THE STAR MODIFICATION 13

ADDENDUM NOISE REPORT

NOVEMBER 2018

The Star Modification 13 Addendum Noise Report

LEVEL 5 KEY PLAN

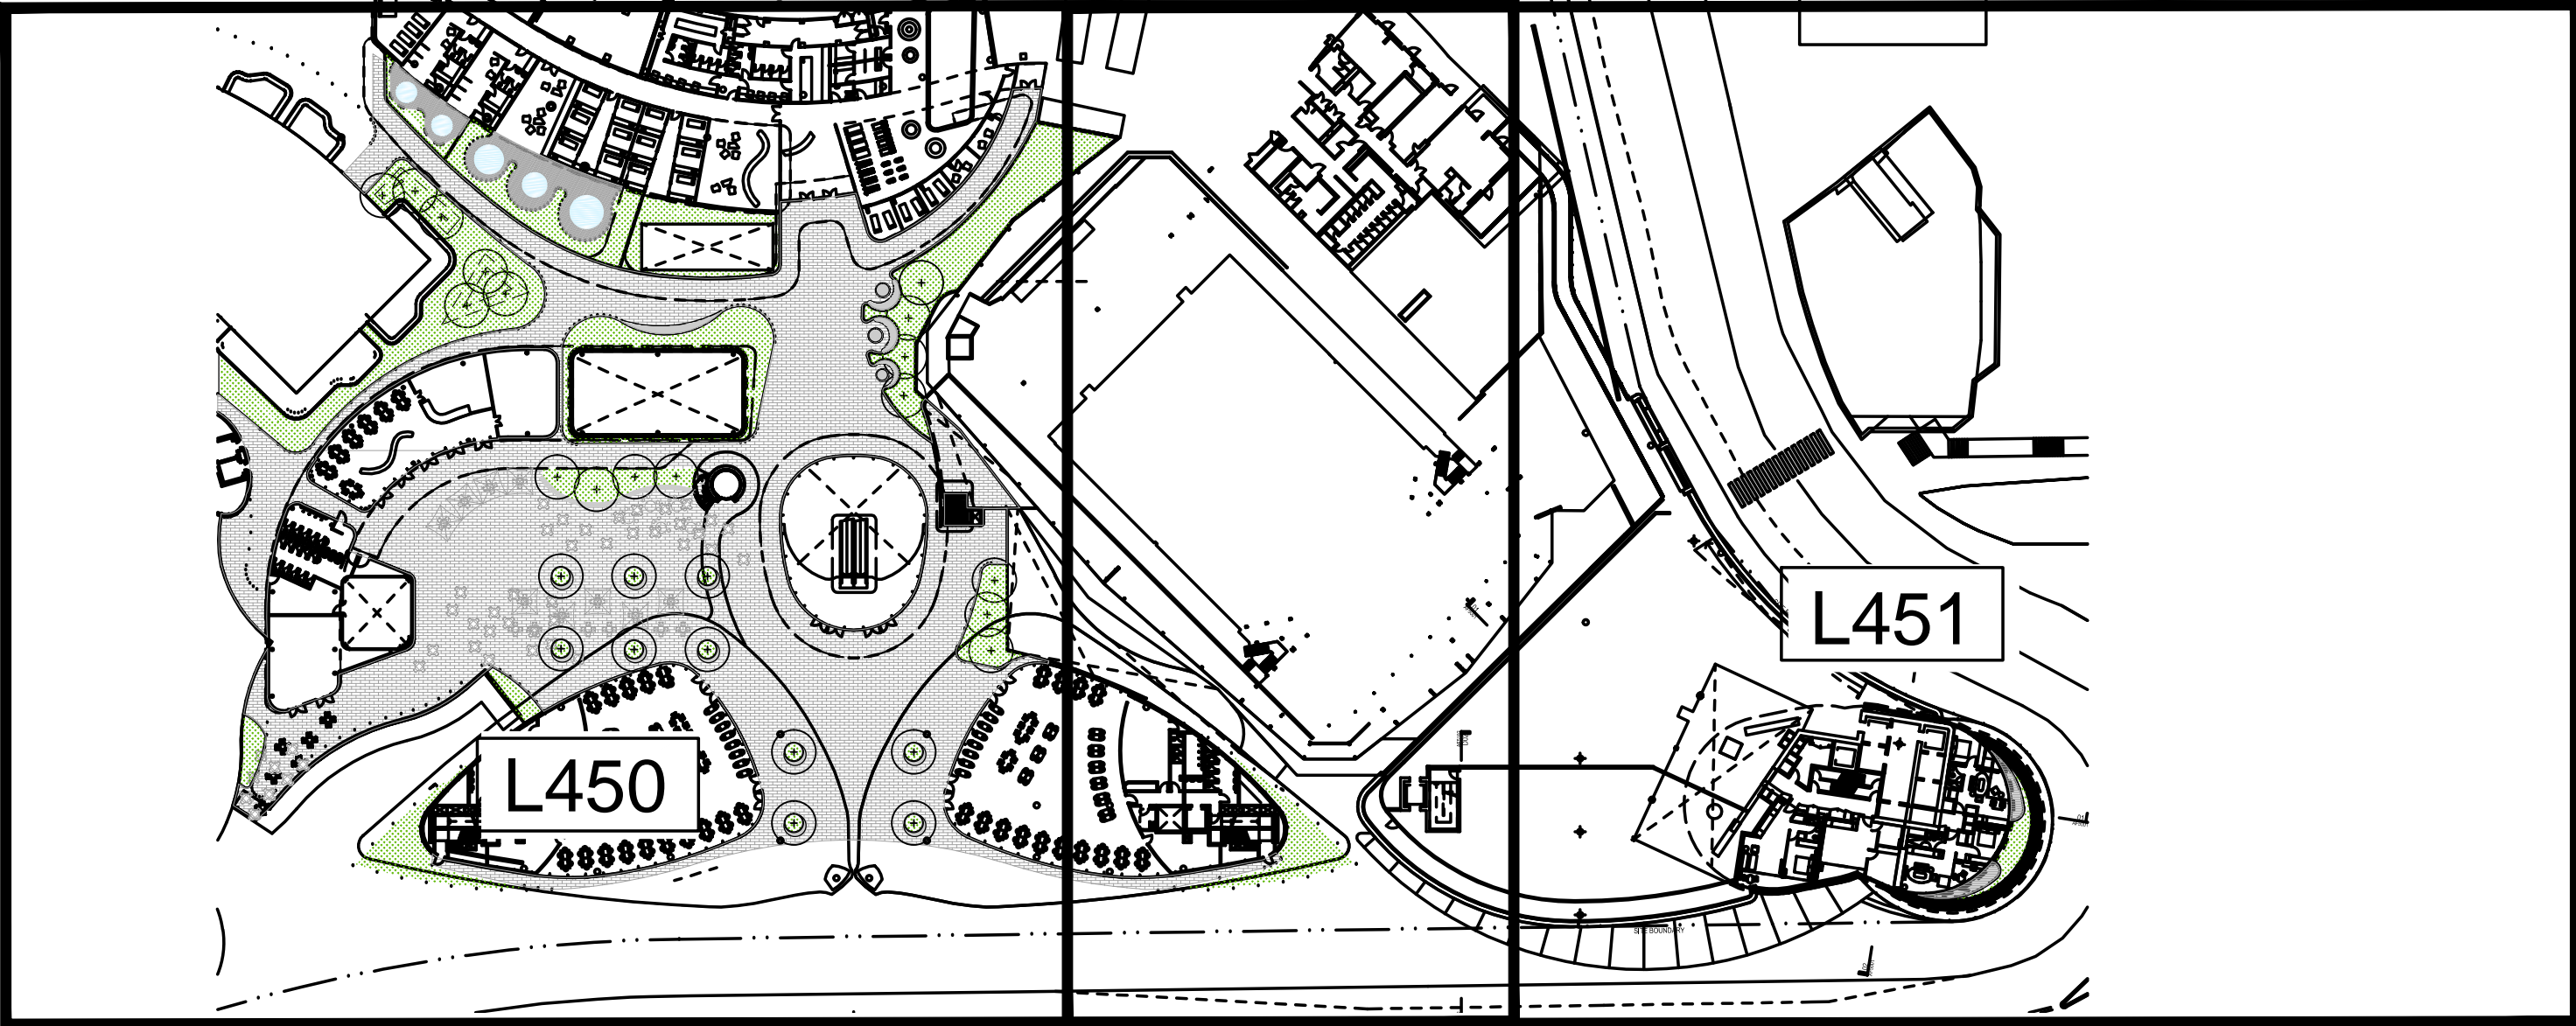
Property owners at numbers 851 and 852 of the Astral Residence at 80 Pirrama Road, Pyrmont, raised concerns relating to the noise impacts from the proposed Level 05 Terrace. An excerpt of the noise-related items is presented below.

- *Modification 13 will intensify the noise impacts on the residents of the Astral building through the activation of uses on Level 5, including 'flexible events/designated event spaces'*

- *The assessment anticipates the installation of eight (8) speakers for the indoor event space and another eight speakers for the outdoor event space over a duration of 7am to midnight and midnight to 7am.*
 - *The Modification 13 proposal appears to have only anticipated impacts to receivers outside of the Star development site, whereas impacts of occupants within the Star development site will also occur and require consideration and appropriate amendment mitigation*
 - *The assessment has minimal regard to sensitive receivers within the Star's own development site*

No loudspeakers are proposed to operate between midnight and 7am for the Level 05 Terrace, as detailed in Section 11.3.1 of the NIA. Management of the loudspeaker operations will be incorporated into the ONMP.

A comparison of the noise impacts resultant from the operation of the proposed Level 05 Terrace against the existing noise environment has been undertaken. A three-dimensional noise model, developed as part of the Noise Impact Assessment (outlined in Section 11.1 of the Noise Impact Assessment), has been used to assess the increase in noise levels compared with the existing situation at the façade most likely to be impacted by the Level 05 Terrace (northern façade).

The assessment of the noise impacts from the Level 05 Terrace aligns with the methodology outlined in Section 11.3 of the Noise Impact Assessment. This is assessed with respect to the worst-case scenario involving the greatest increase in noise sources due to the proposed Level 05 Terrace development, which aligns with the 7am to midnight scenario outlined in Table 11.9 of the NIA.

Predicted noise levels at the Northern façade of the Astral Residences indicate that future noise impacts are similar to the existing noise impacts at the onsite residences, with the highest predicted increase to be less than 2 dB, which is not considered a significant change in noise level.
